City of Portland, Maine - Building or Use Permit Application

Permit No: 04-0339	Issue Date: APR 28 2004	CBL: 376 A052001
-----------------------	----------------------------	---------------------

RE: C. of O. for #20 Farm House Lane
(CBL376A052) (ID 2004-0063)

2004-0063

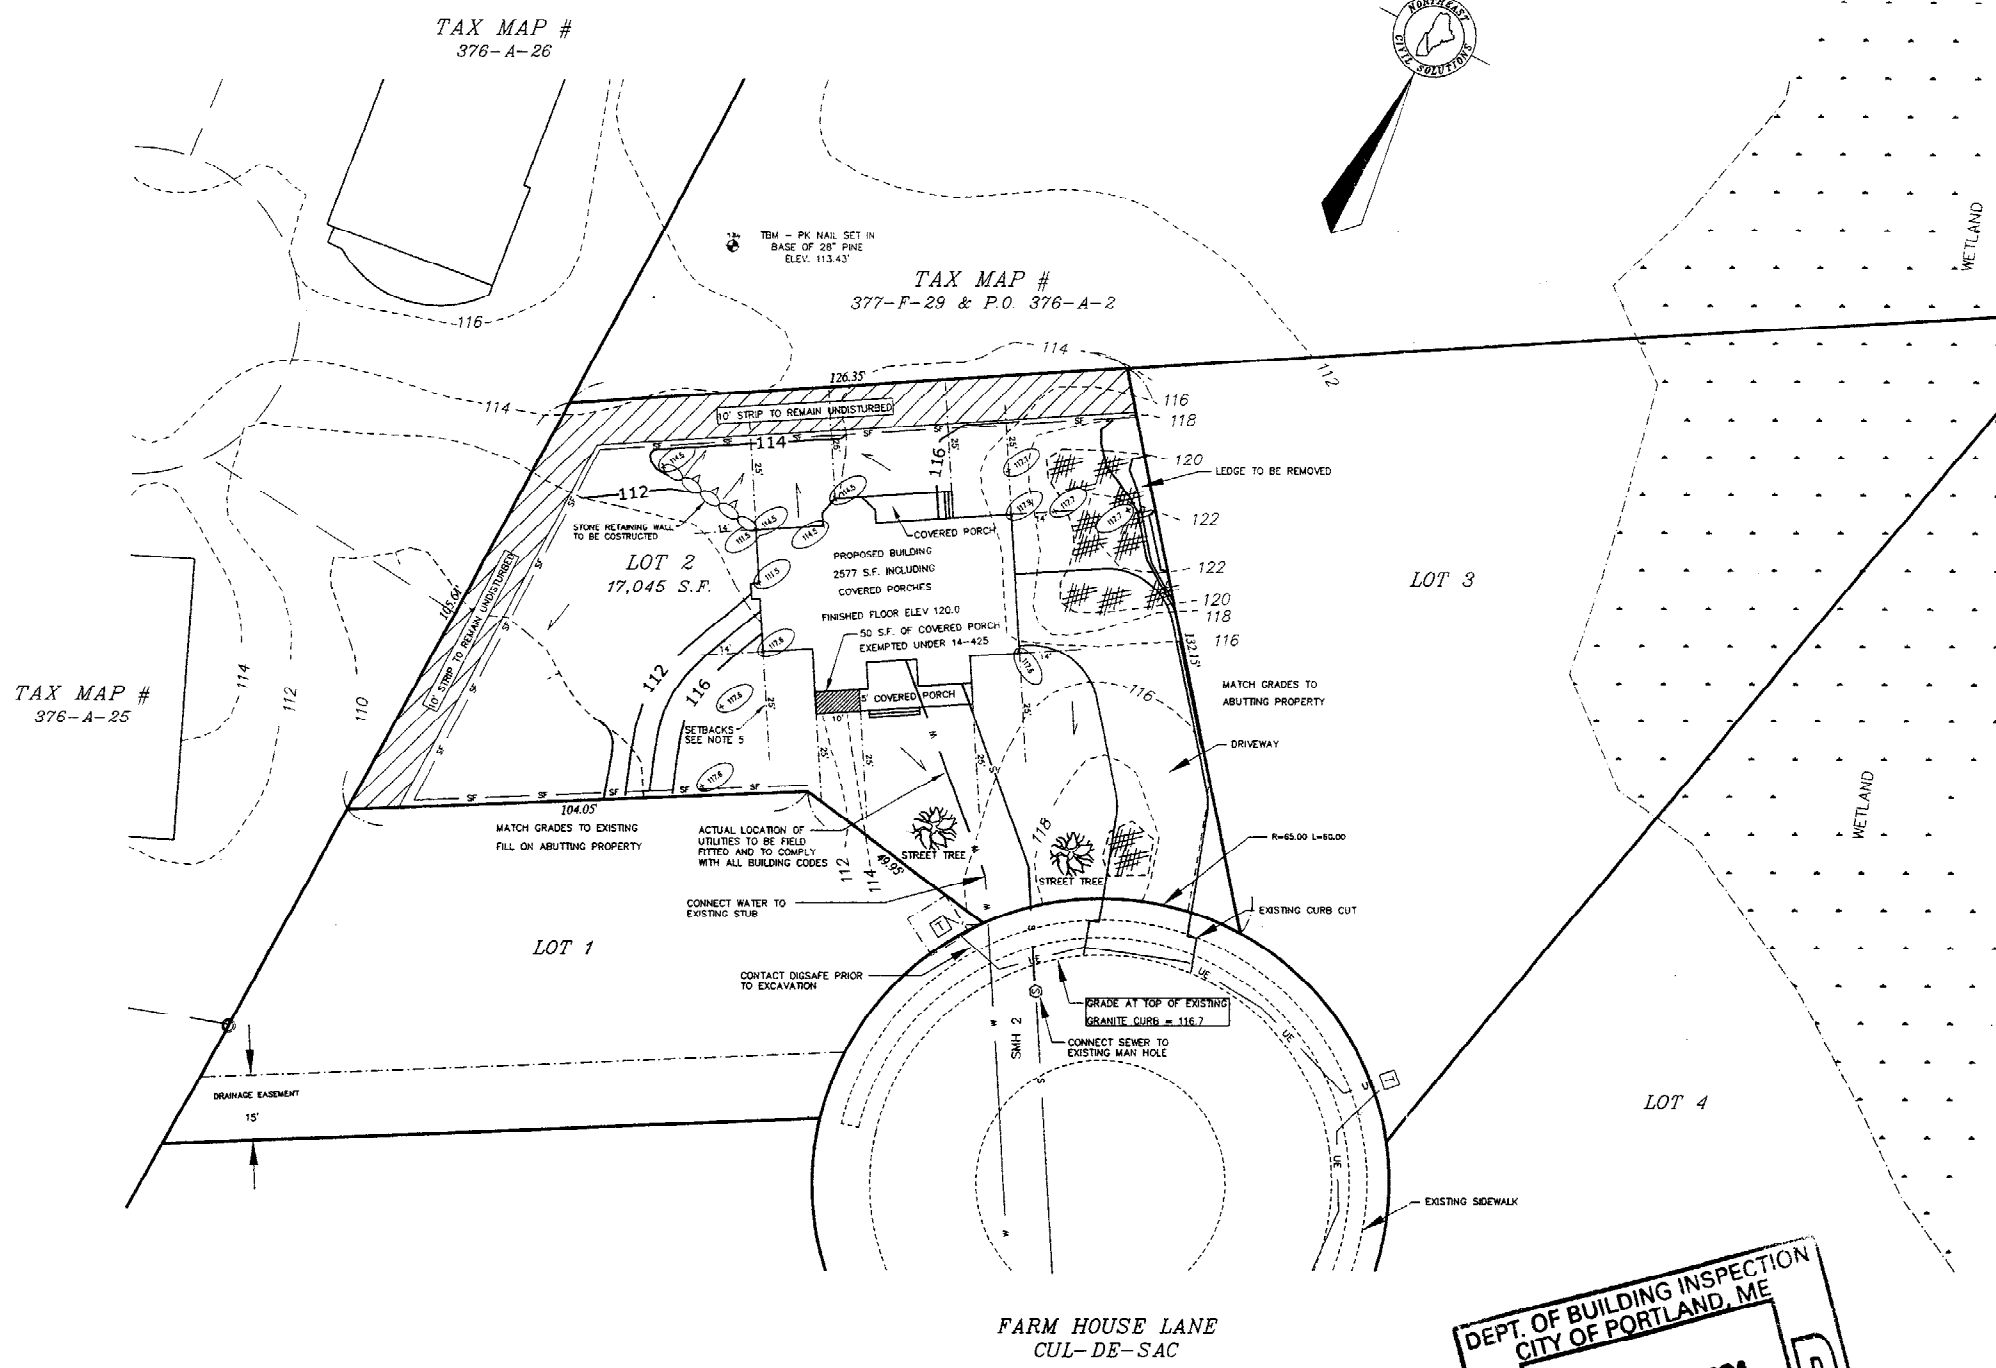
- 1 Grading does not match the proposed grading on the subdivision plans. This is acceptable, being that the intent and overall drainage flow directions and quantities are not changing.

Typical Foundation Wall
Scale: 1/2" = 1'-0"

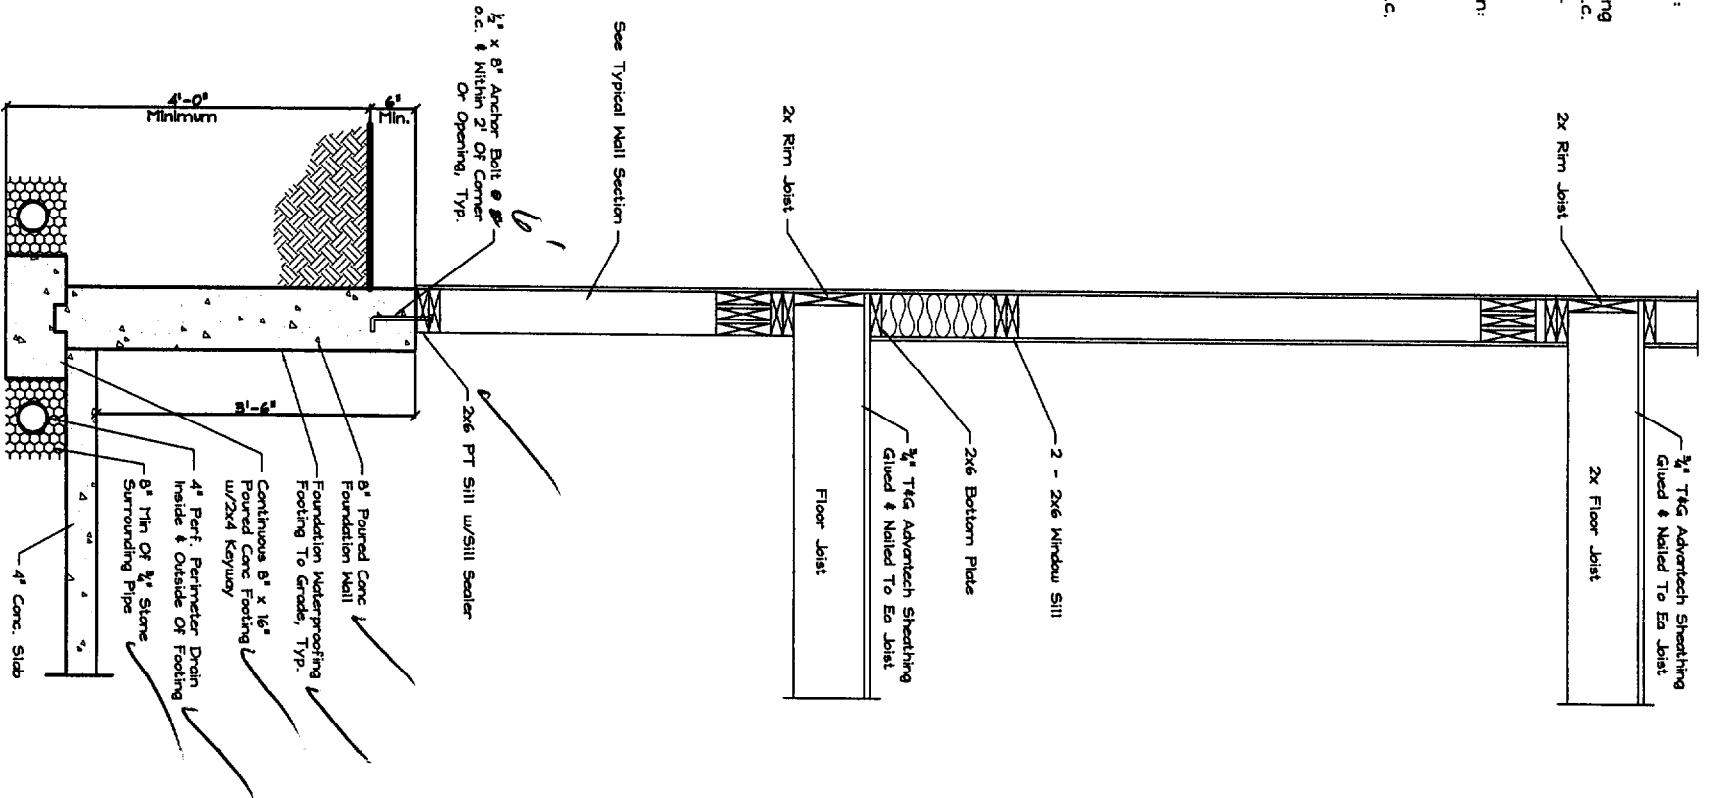
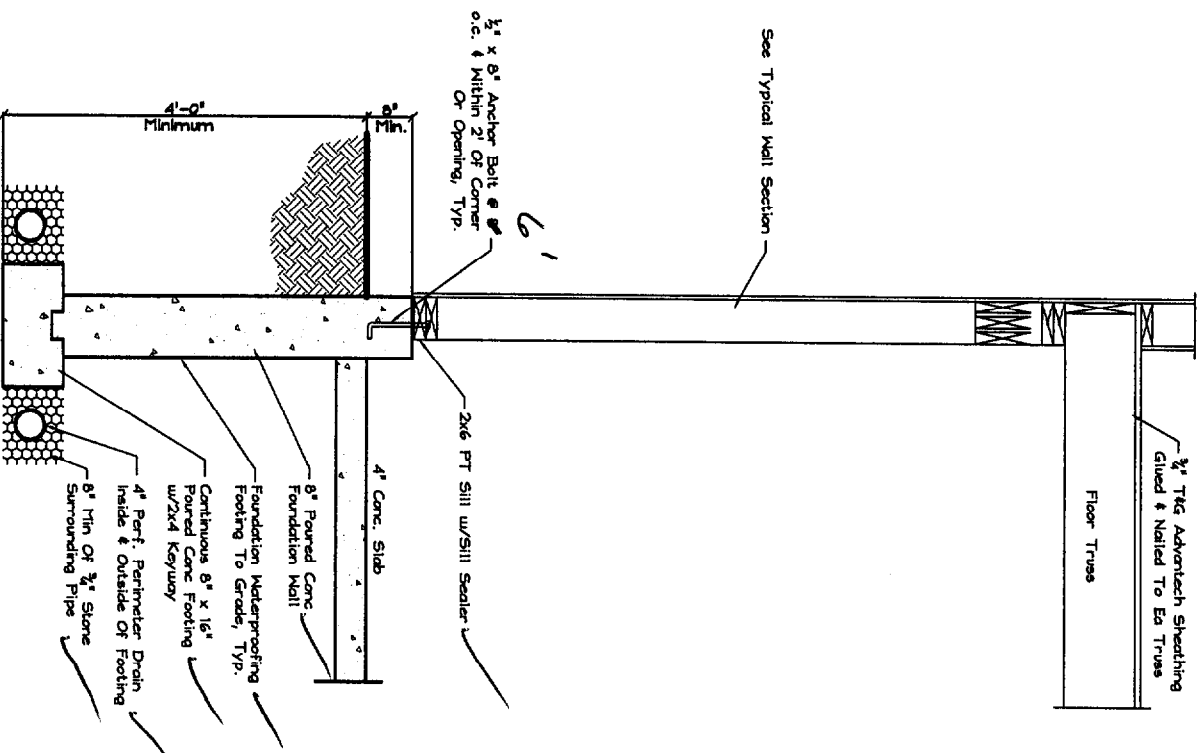
Anchor bolts - Max 6' oc -

shows 8' oc - OK 4/28/04
